File No: NTH 10/00202/04
Your Ref: MP07_0026_MOD5

Proposed Modification to Ballina Pacific Pines Development, Lennox Head MP07_0026 MOD5

Roads and Maritime Response

EPIQ LENNOX HEAD
ILLUSTRATION
C6 - MOVEMENT NETWORK
CLIENT: CLARENCE PROPERTY CORPORATION
LOCATION: LOT 234 DP1104071
LENNOX HEAD NSW

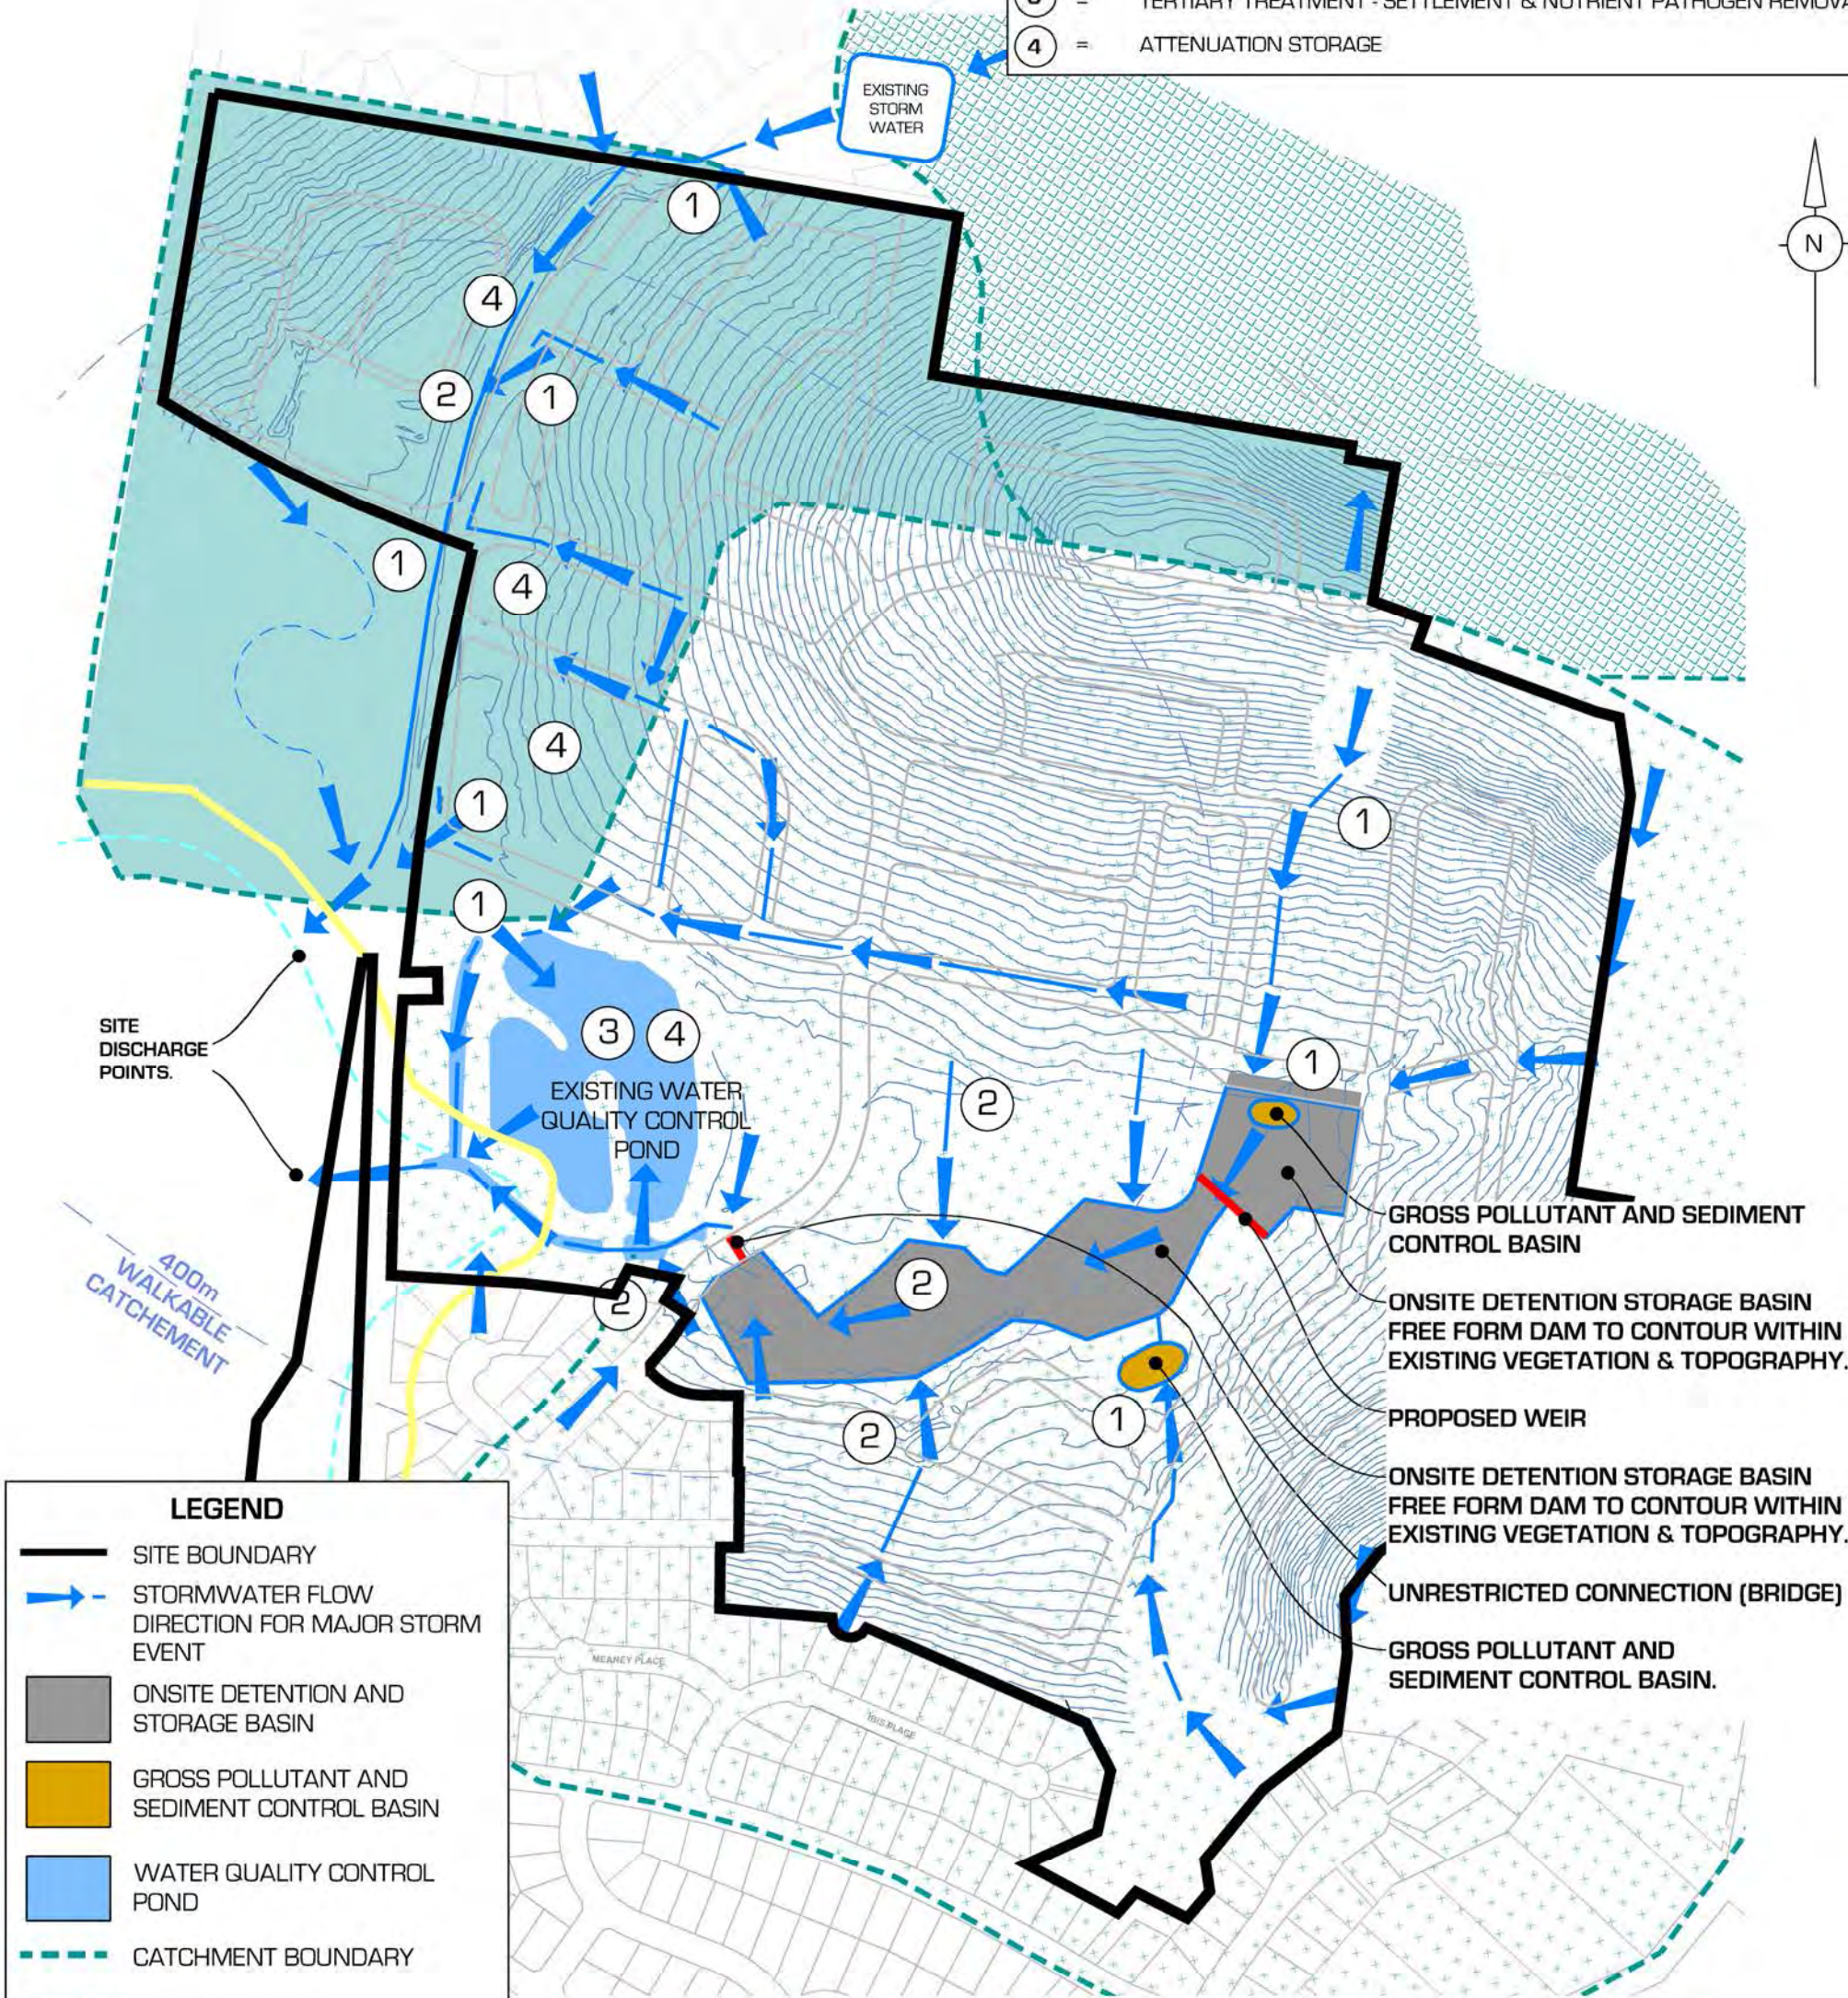
- Section 6.5 of the TIA identifies the need to upgrade the Henderson Lane and Montwood Drive intersections with North Creek Road. Both intersections are close to downstream junctions. After reviewing the traffic generation calculations, the design of these intersections should be further investigated to ensure that sufficient separation of intersections treatments can be achieved to provide the required vehicle storage, deceleration and taper lengths for traffic turning from North Creek Road.
